Our Ref: LU/199/21/NMA

Non material amendment following the grant of LU/121/17RES to re-locate the dwellings northwards by 1 metre, replacement housetype from a wide front 3 bed to a standard 3 bed on plot 126 and changes to front door position on plot 126.

Phase 2 Hampton Park Toddington Lane Littlehampton BN17 7PL

Site:	Date:
Phase 2 Littlehampton	Oct. 2020
Scale:	1:100 @ A3
Dwg No:	543_PL_APP3_3520A_2420A_E_200

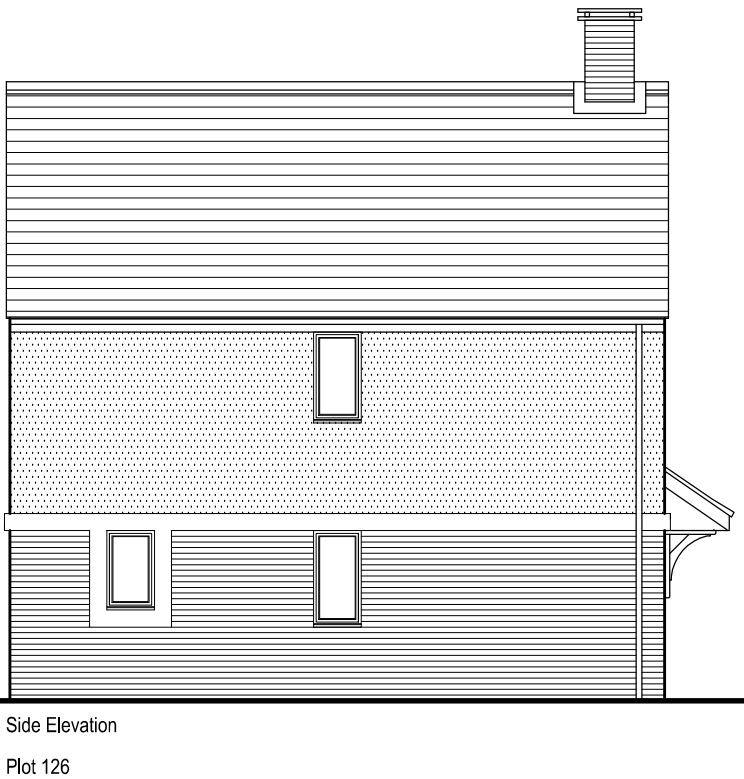
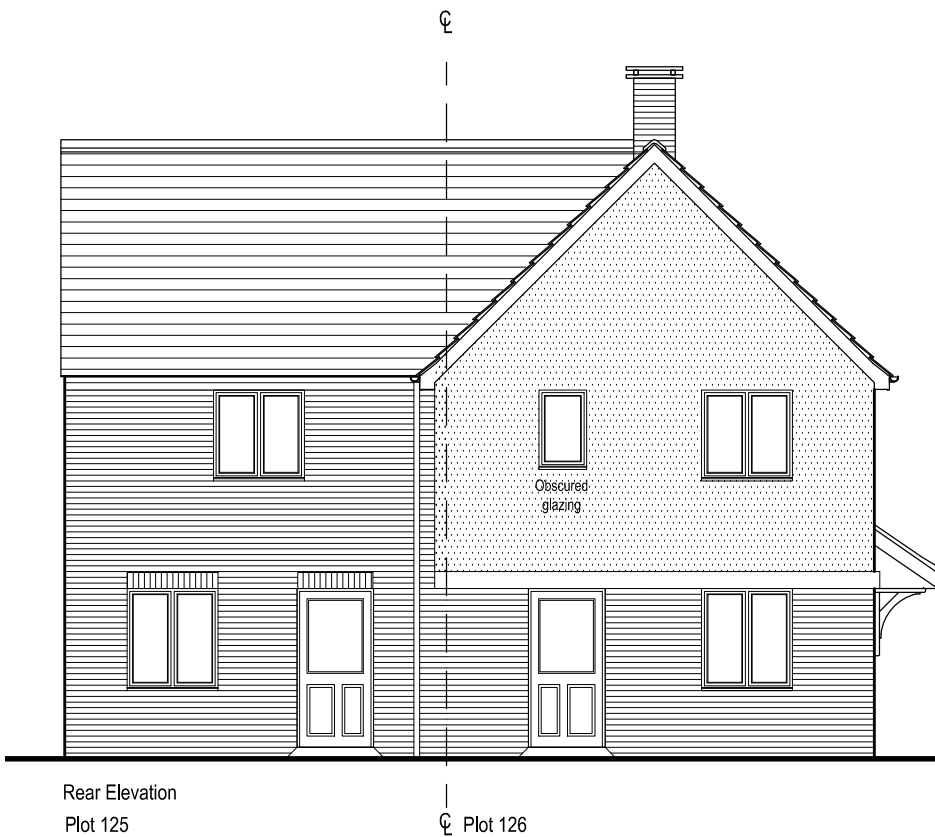
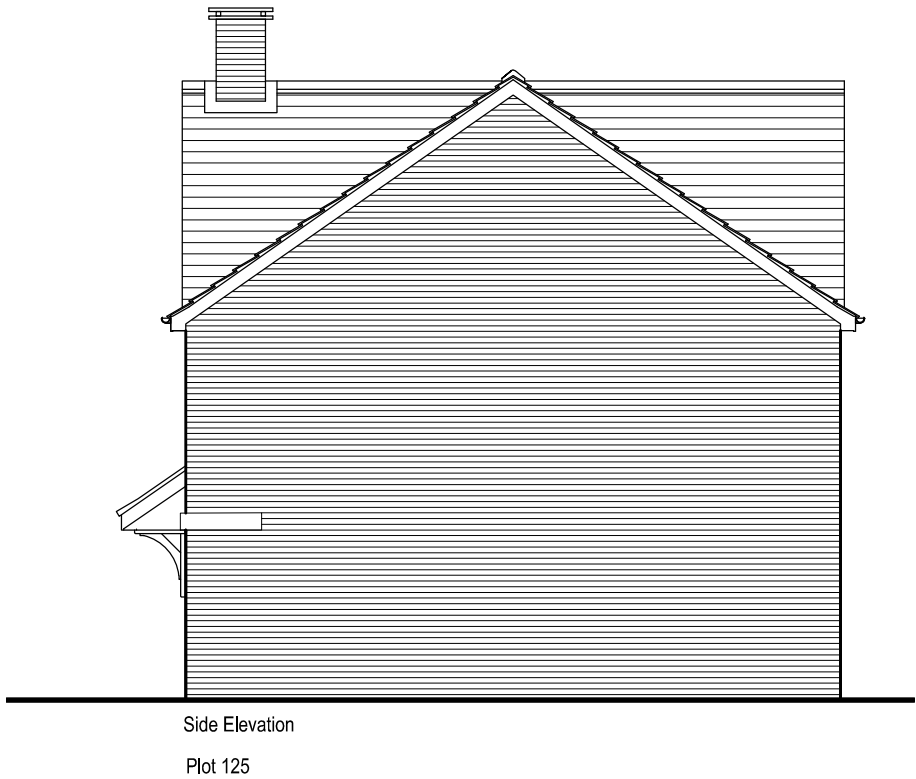
From the information submitted, I am prepared to take the re-location of the 4 dwellings northwards by 1.0 metre, to replace the house-type on Plot 126 from a wide front 3 bed to a standard 3 bed dwelling, to change the position of the front door on Plot 126 and to rationalise the southern edge of the site as a Minor Non-Material Amendment to reserved matters

Please note that Drawing No. 543_PL_APP3_001 Rev. A - 3rd NMA Application Revised Red Line, Drawing No. 543_PL_APP3_100 Rev. A - 3rd NMA Application Site Layout: Plot 123-126, Drawing No. 543_PL_APP3_3520A_2420A_E_200 - Proposed Elevations: Plots 125-126 and Drawing No. 543_PL_APP3_3520A_2420A_P_100 - Proposed Floor Plans: Plots 125-126 now form part of the approved planning drawings for reserved matters approval LU/121/17/RES at Phase 2 at Hampton Park in place of:

Site:	Phase 2 Littlehampton	Date:	February 2017
Scale:	1:100 @ A3	Org No:	F43_FL_WP3520C/2420A_P_101

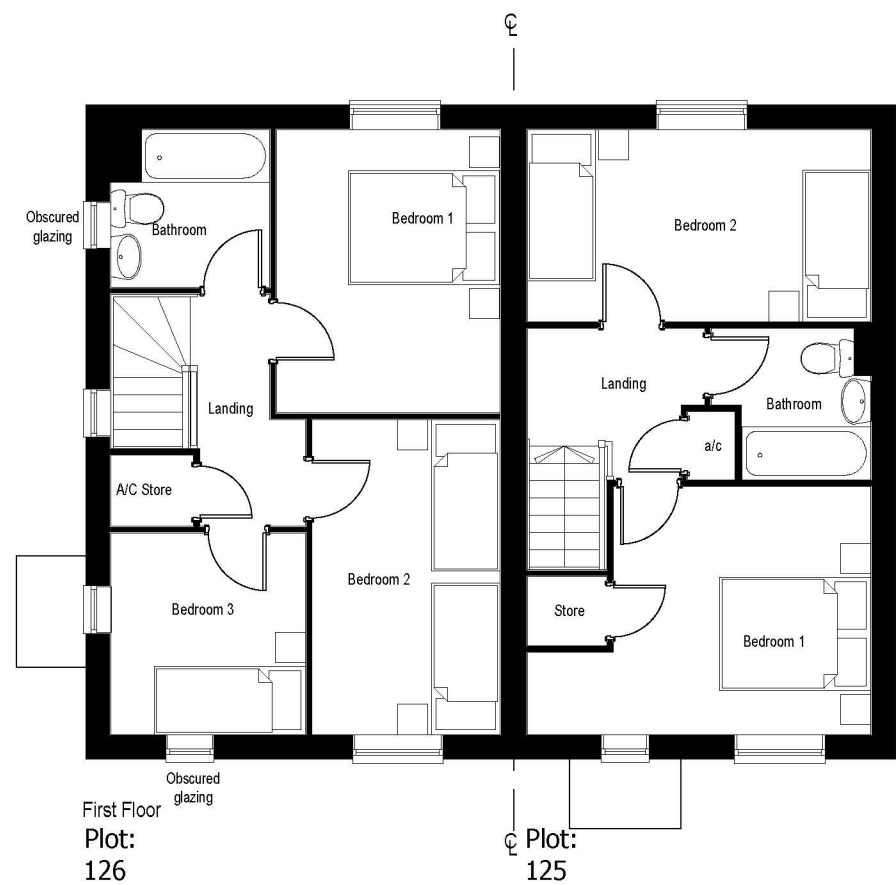
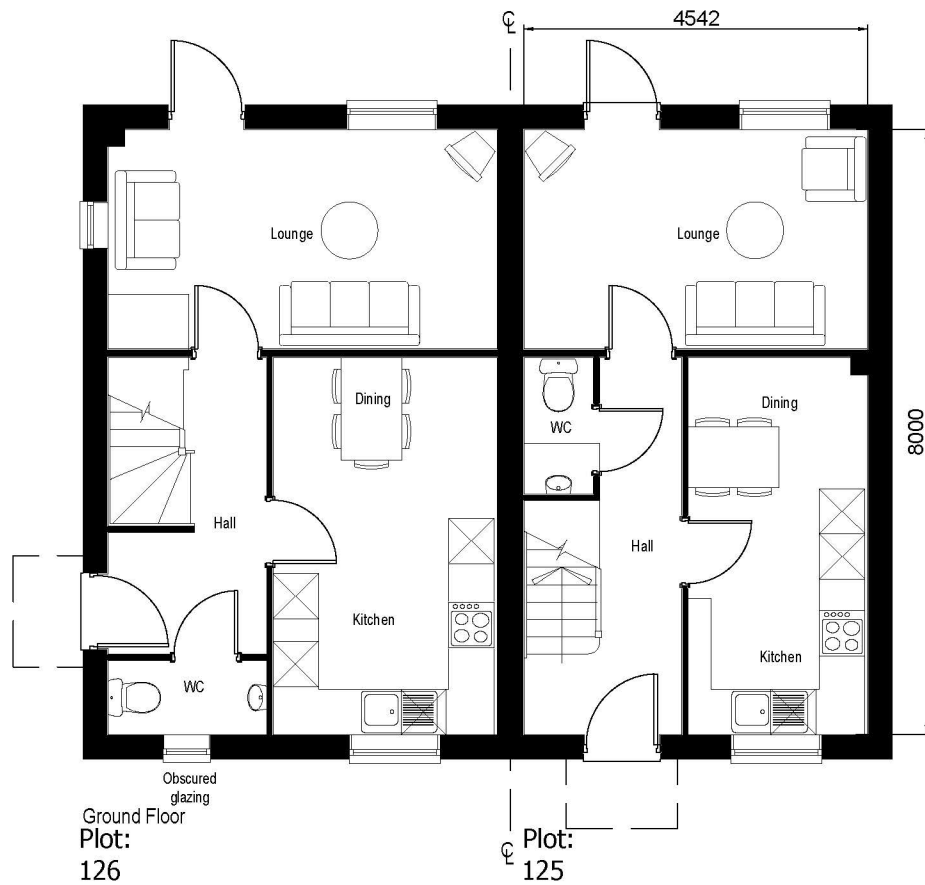
Drawing Number 543_PL_WP3520C/2420A_E_201 Rev. B - WP3520C and WP2420A Proposed Elevations (2 of 3) and Drawing Number 543_PL_WP3520C/2420A_P_101 Rev. A - WP3520C and WP2420A - Proposed Plans (2 of 3).
